Application No: AB/60/21/HH
Site Address: 4 Penfolds Place Arundel BN18 9SA
Description of works: Single storey rear extension under flat roof with roof light. Two storey front extension to provide new ground floor playroom/study, porch and hallway; first floor bedroom and family bathroom.

Thank you for your internet representation made on 1st August 2021 which has been recorded as an objection with the comments as follows:

Proposed Block Plan

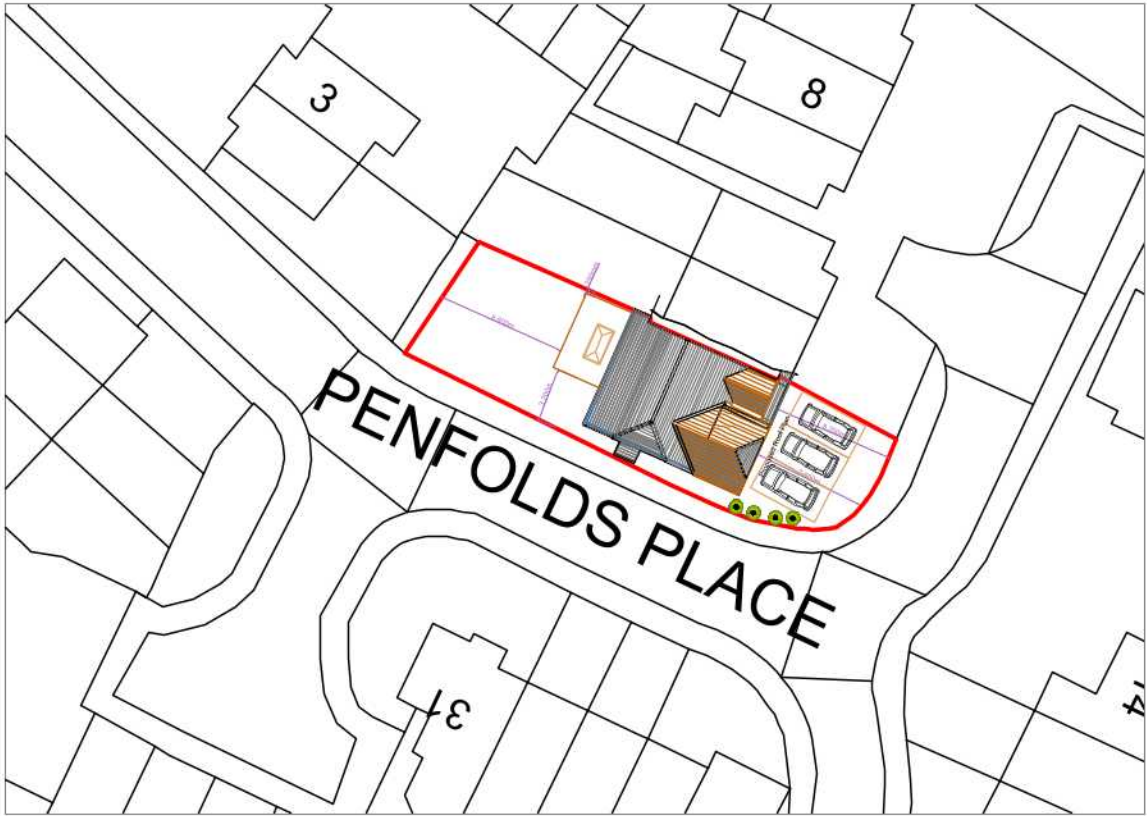
Extending beyond the current building line will change the aesthetics of the entire block of six properties. No other resident has extended the front of their property when modifying their internal space. If approved it will set a precedent.
